PROJECT TITLE: Longacre Subdivision ZONE MAP/DRG.FILE# H-12 / D017
DRB#: 1005450 EPC#: _____ WORK ORDER#: _____

November 25, 2008

Re: Longacre Subdivision Grading and Drainage Plan
Engineer's Stamp dated 10-20-08 (H12/D017)

**GRADING AND DRAINAGE PLAN**

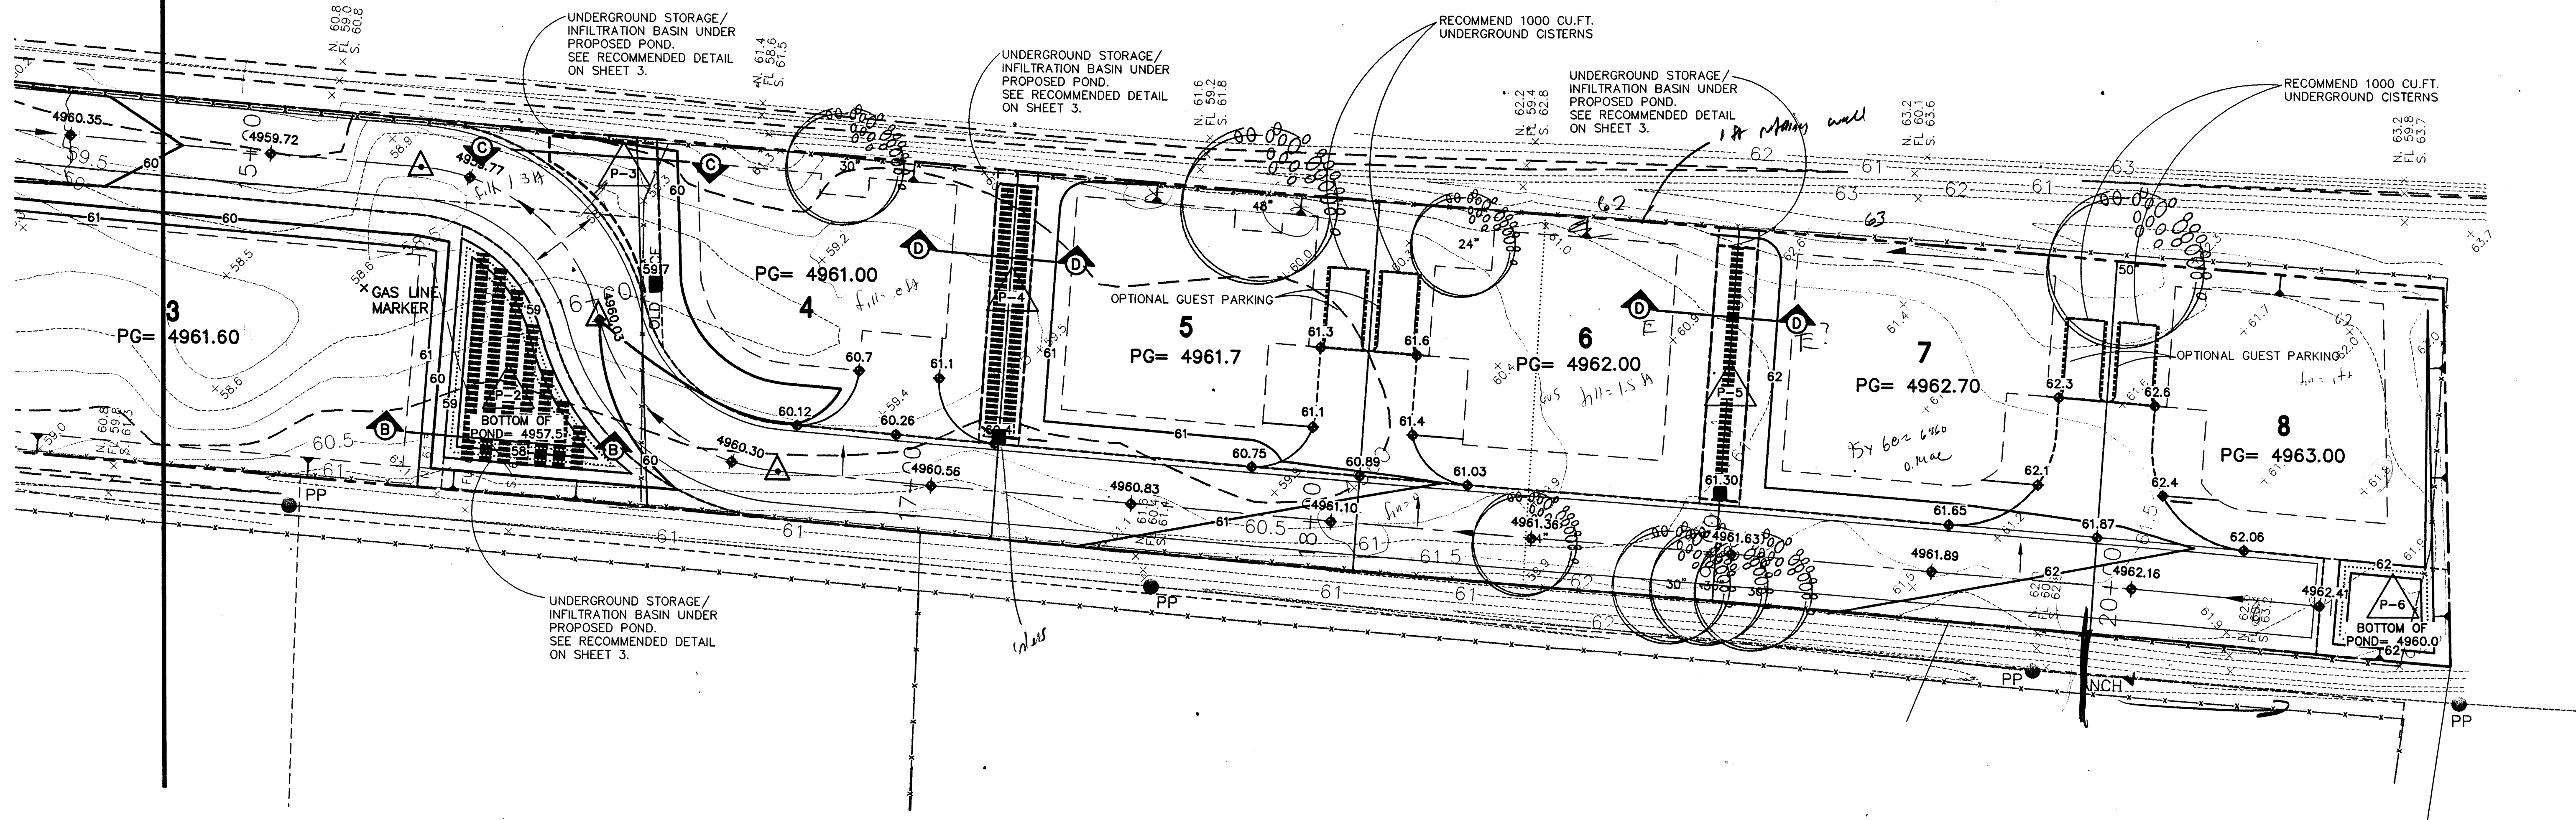
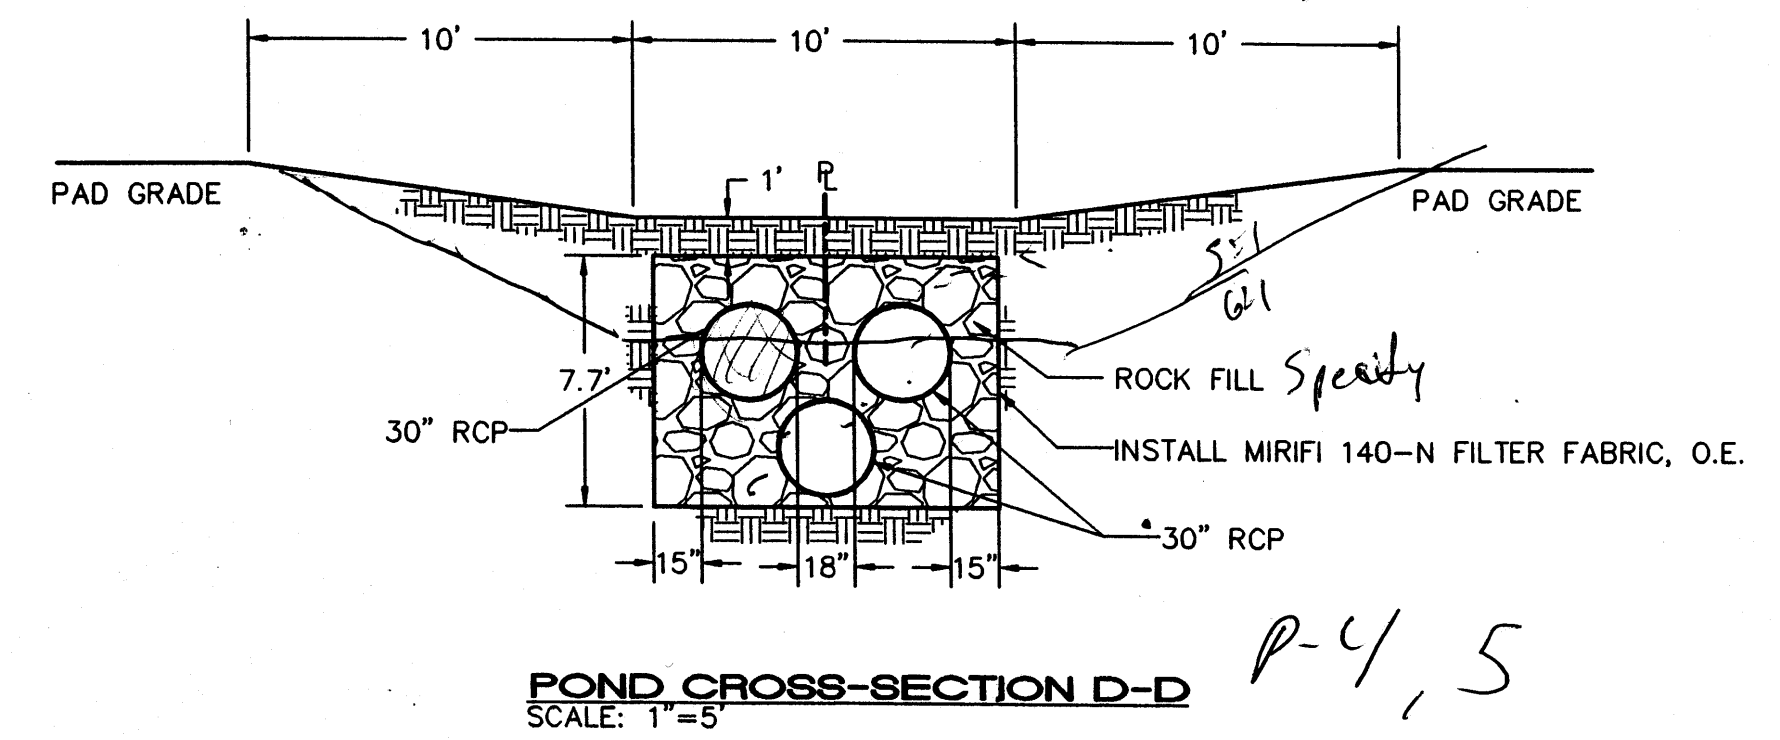
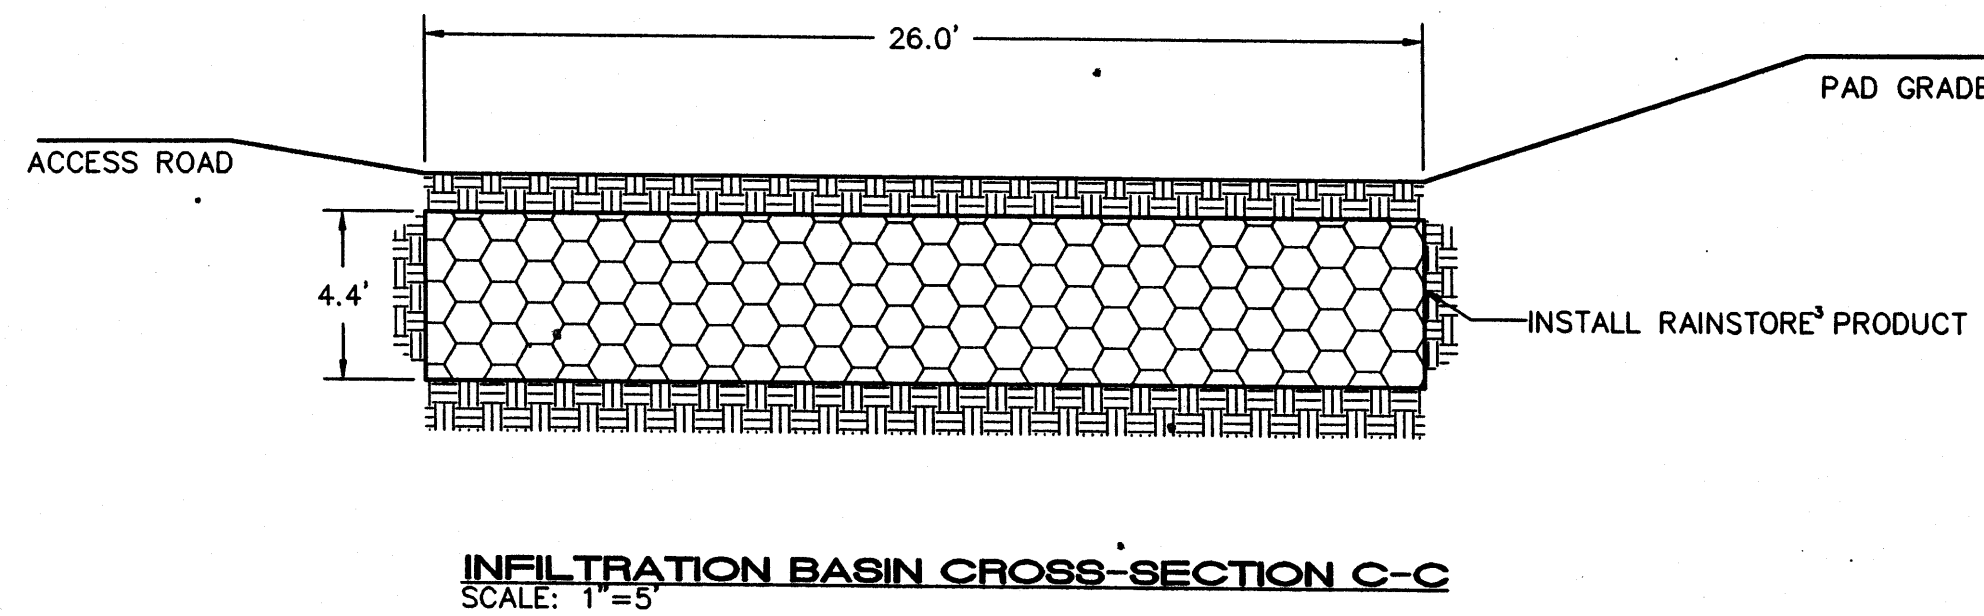
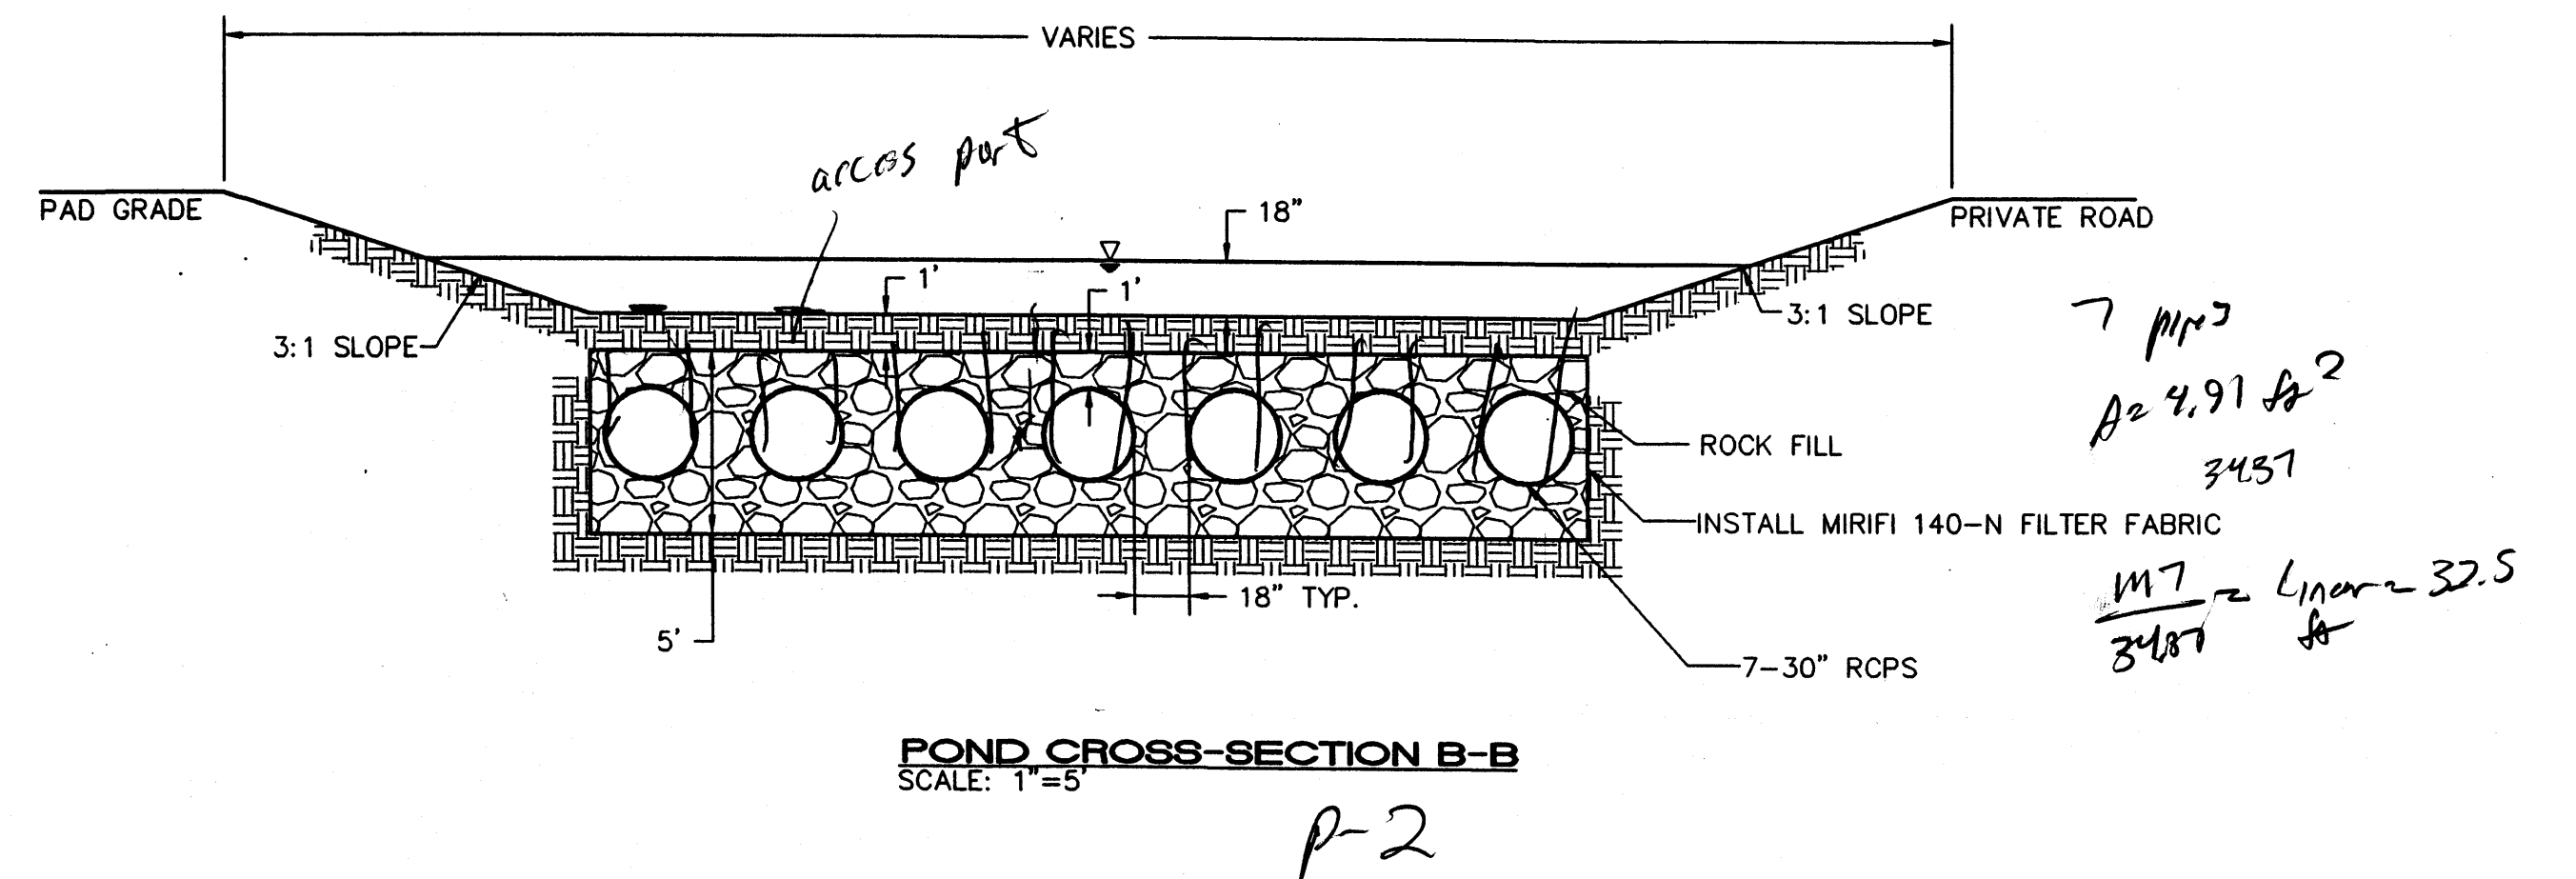
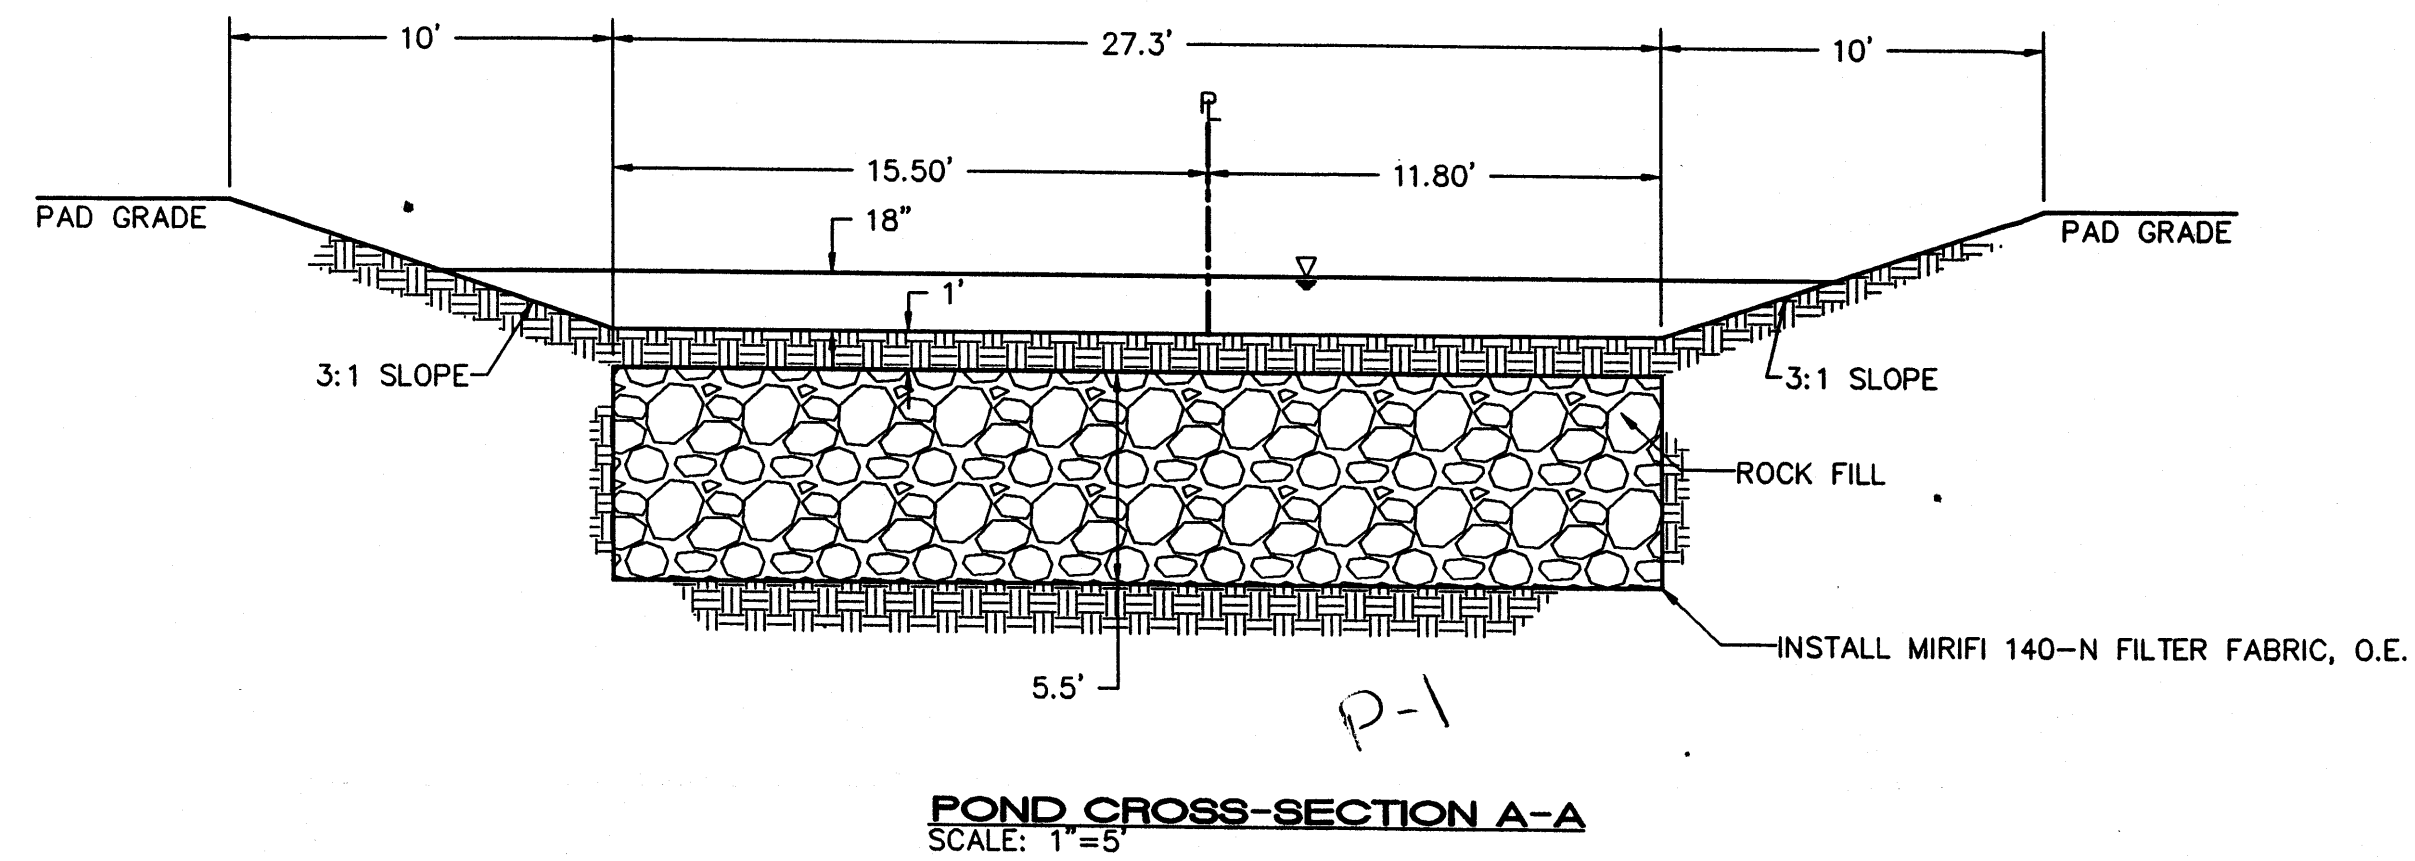
- Provide an entry point/area for runoff to enter the infiltration basin. Otherwise, runoff will take too long to enter the infiltration basin and the pond will not have capacity to contain the runoff.

- Provide a 1' minimum retaining wall around the perimeter of the subdivision. This wall must maintain the 100 yr-24 hour storm volume.
- Finished pad elevation must be 1 foot above the 100 yr-10 day storm water surface elevation. Provide the WSE for each pond.

- How is the Rainstore product maintained?
- How deep is the water table?
- Basin 2 will not drain with a perimeter wall and the Finished Floor of the existing buildings is lower than the surrounding grades.

- There does not appear to be access ports to the buried RCP. Access to an underground retention system is required.
- Should the street be super-elevated to drain away from the houses?

| <b>RECOMMENDED DETAILS</b>  |               |       |                  |

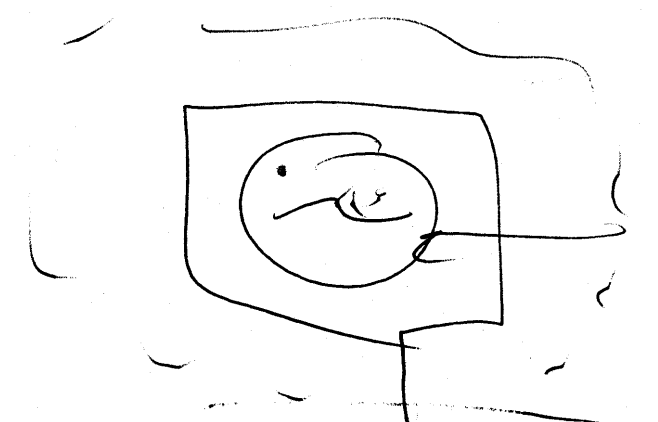
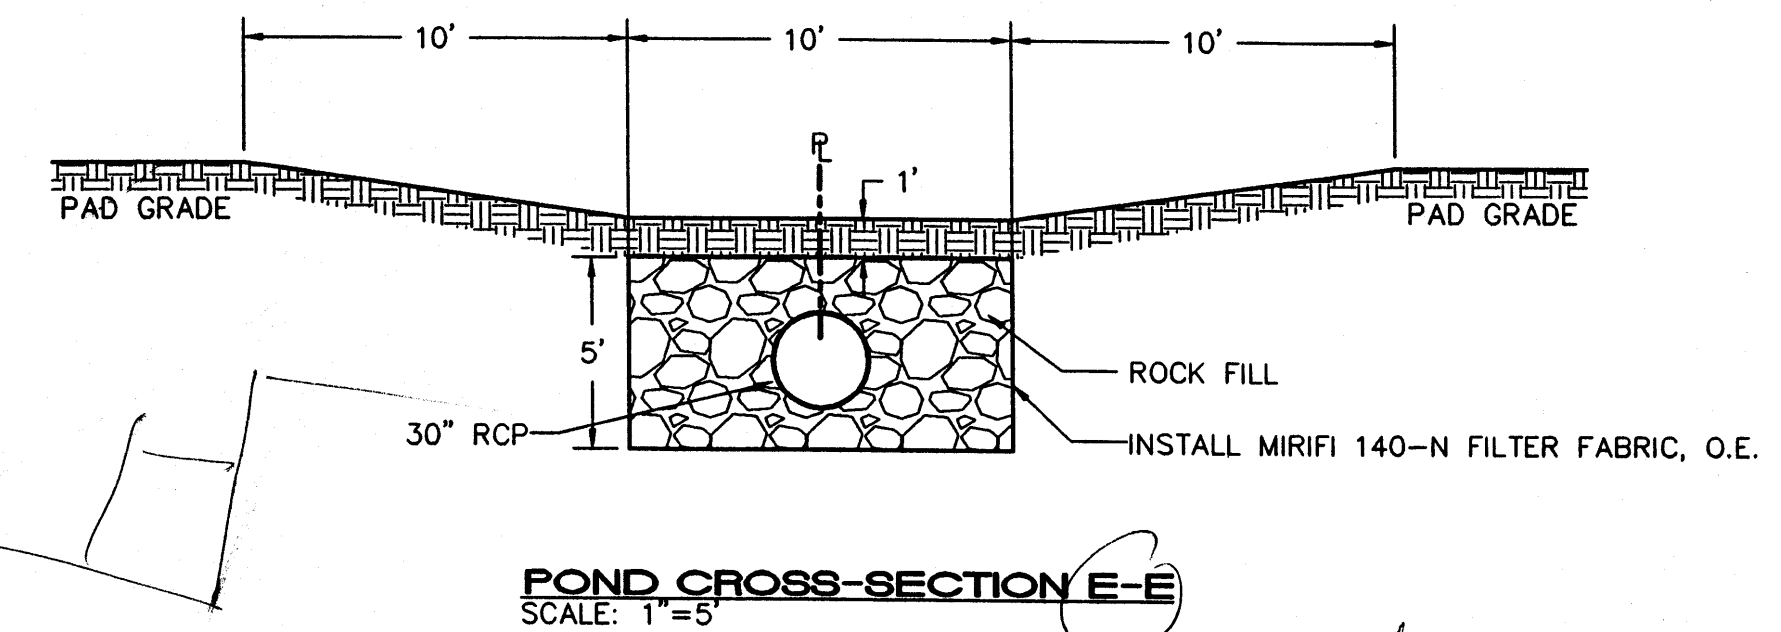
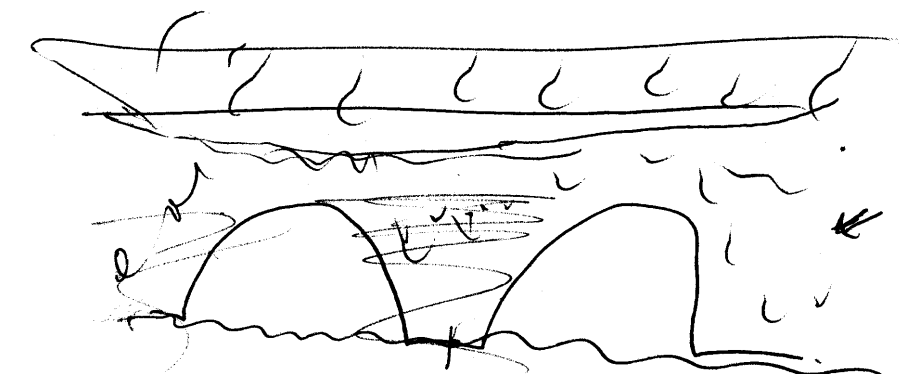
- Provide details for the 1000 cu. ft. cisterns.
- Specify the rock size to be used in the infiltration basins and basis for 30% voids used in calculations.
